**Our Ref: AB/121/18/HH**  
**Your Ref:**

**Town & Country Planning Act 1990 (as amended)**  
**Town & country Planning (Development Management Procedure) (England) Order 2015**  
**Application for Planning Permission for Works or Extension to a Dwelling**

**Development**     New velux roof window in rear elevation  
**Location**        35 Maltravers Street Arundel

EXISTING SECOND FLOOR PLAN
SCALE 1:100

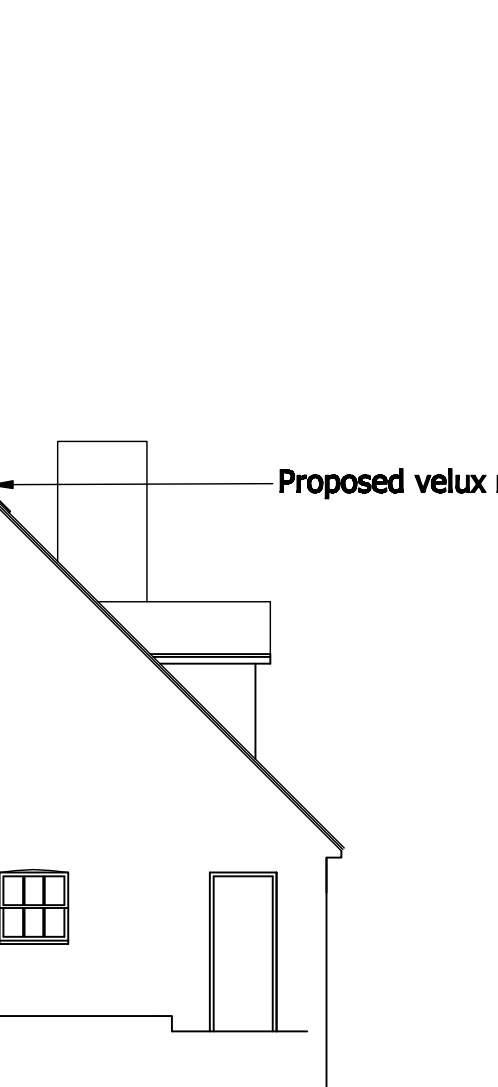
Confirmation Required: The existing second floor/loft plan appears to show a bathroom however the bathroom isn't present on the proposed second floor/loft plan. Please confirm whether there is any work to the bathroom and amend your plans accordingly.
